**Our Ref: A/61/11/
Your Ref:**

Please ask for:
Miss C Burrows
01903 737500 Ext 37459
12th April 2011

**Rear porch extension
12 Mill Road Angmering**

Drawing: **EXISTING** (RETROSPECTIVE)

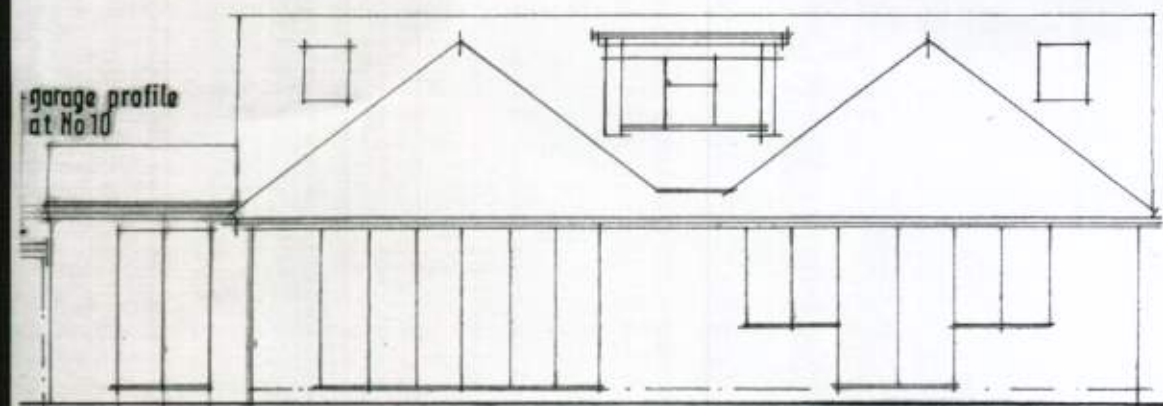
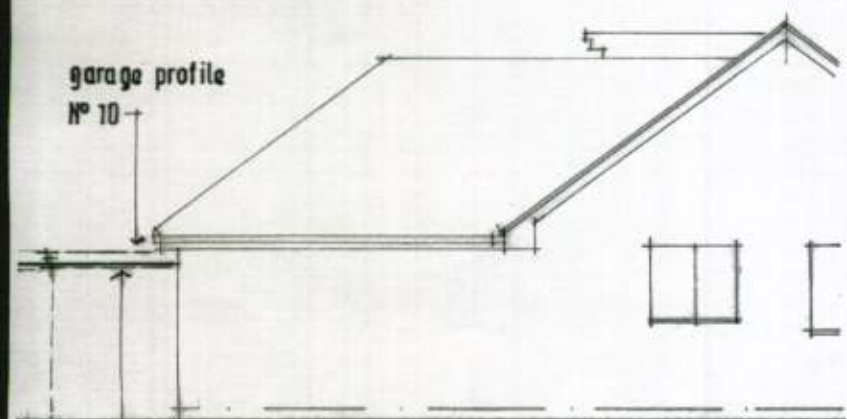
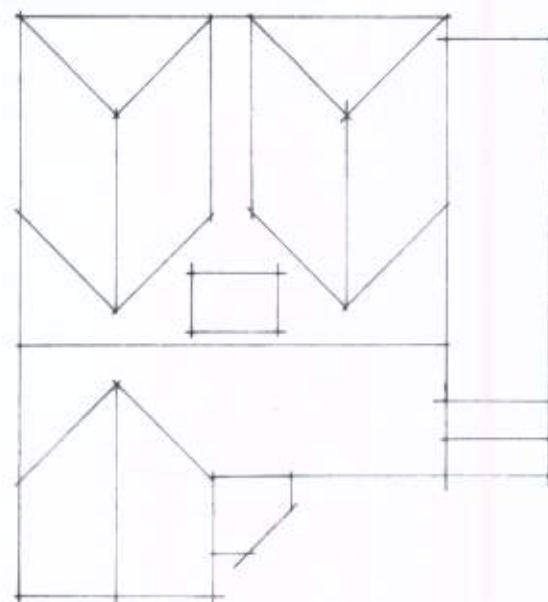
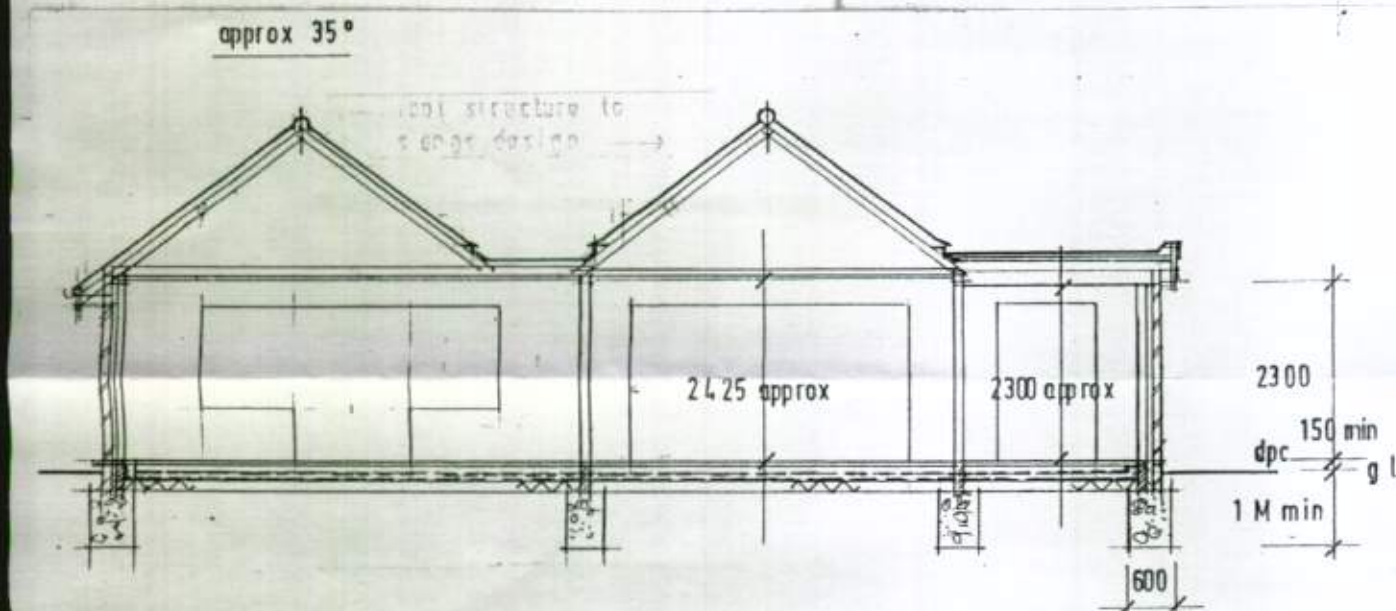
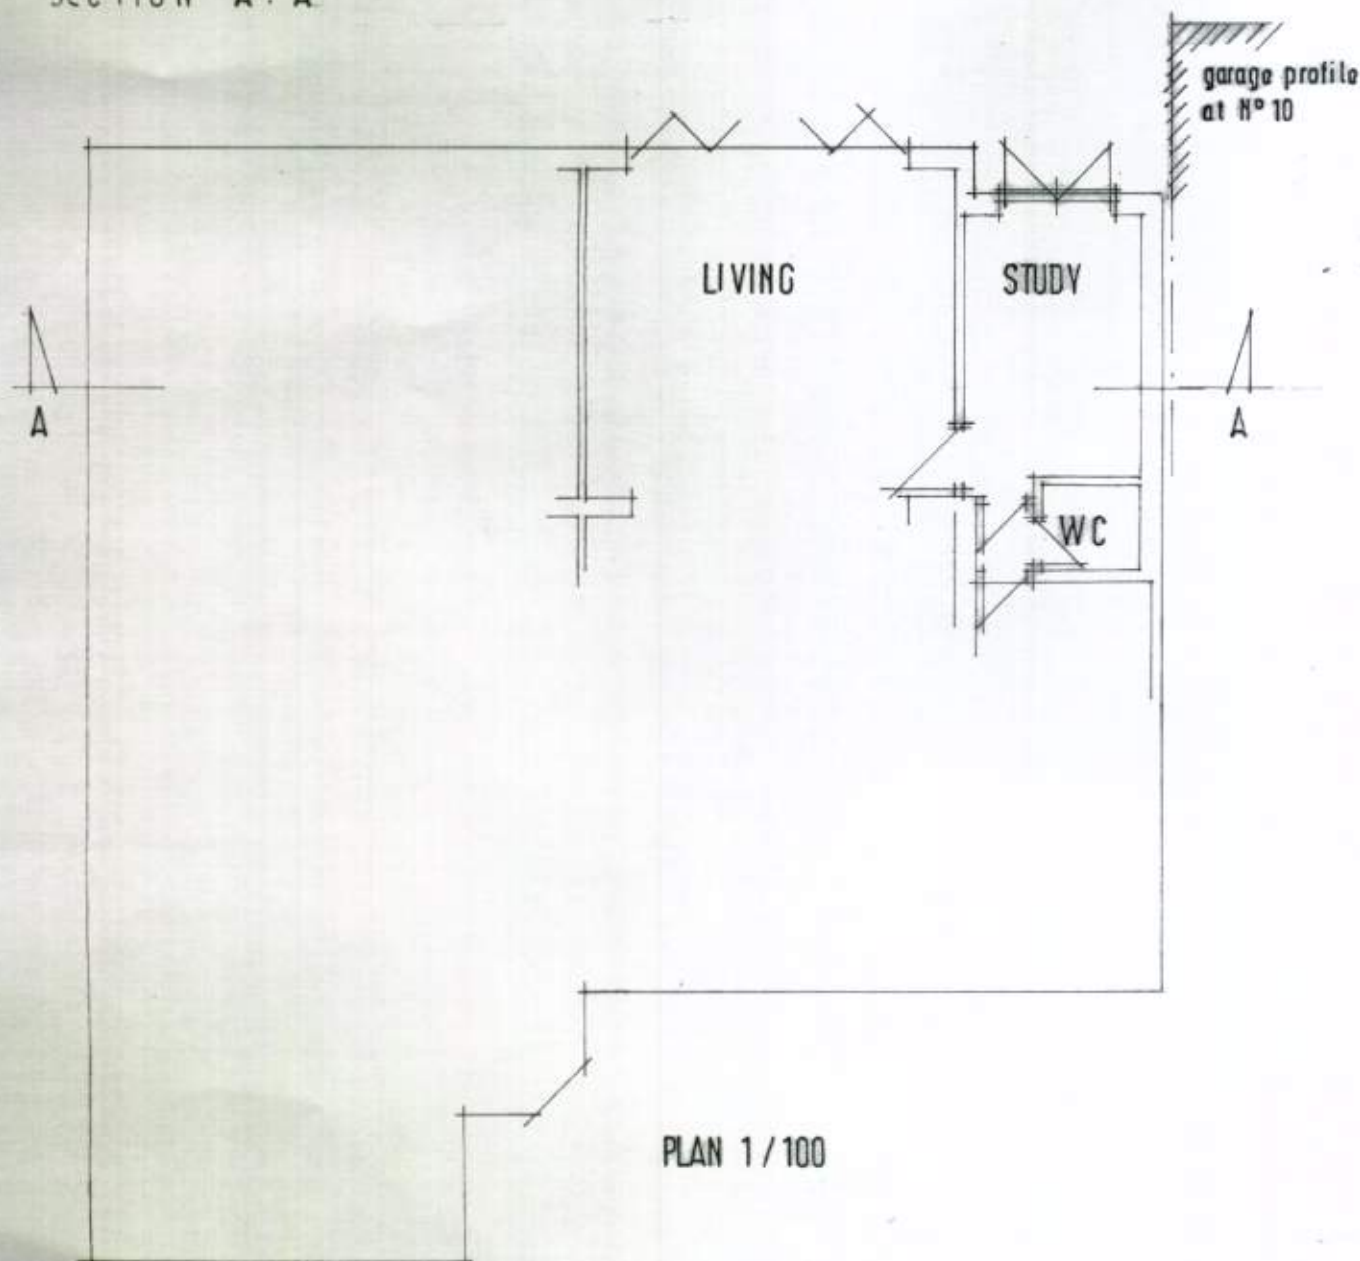
Please provide revised existing Ground floor plans, Elevations and Sections. They need to be up to date and relevant plans, the plans you have submitted are very misleading as they relate to a previous application.
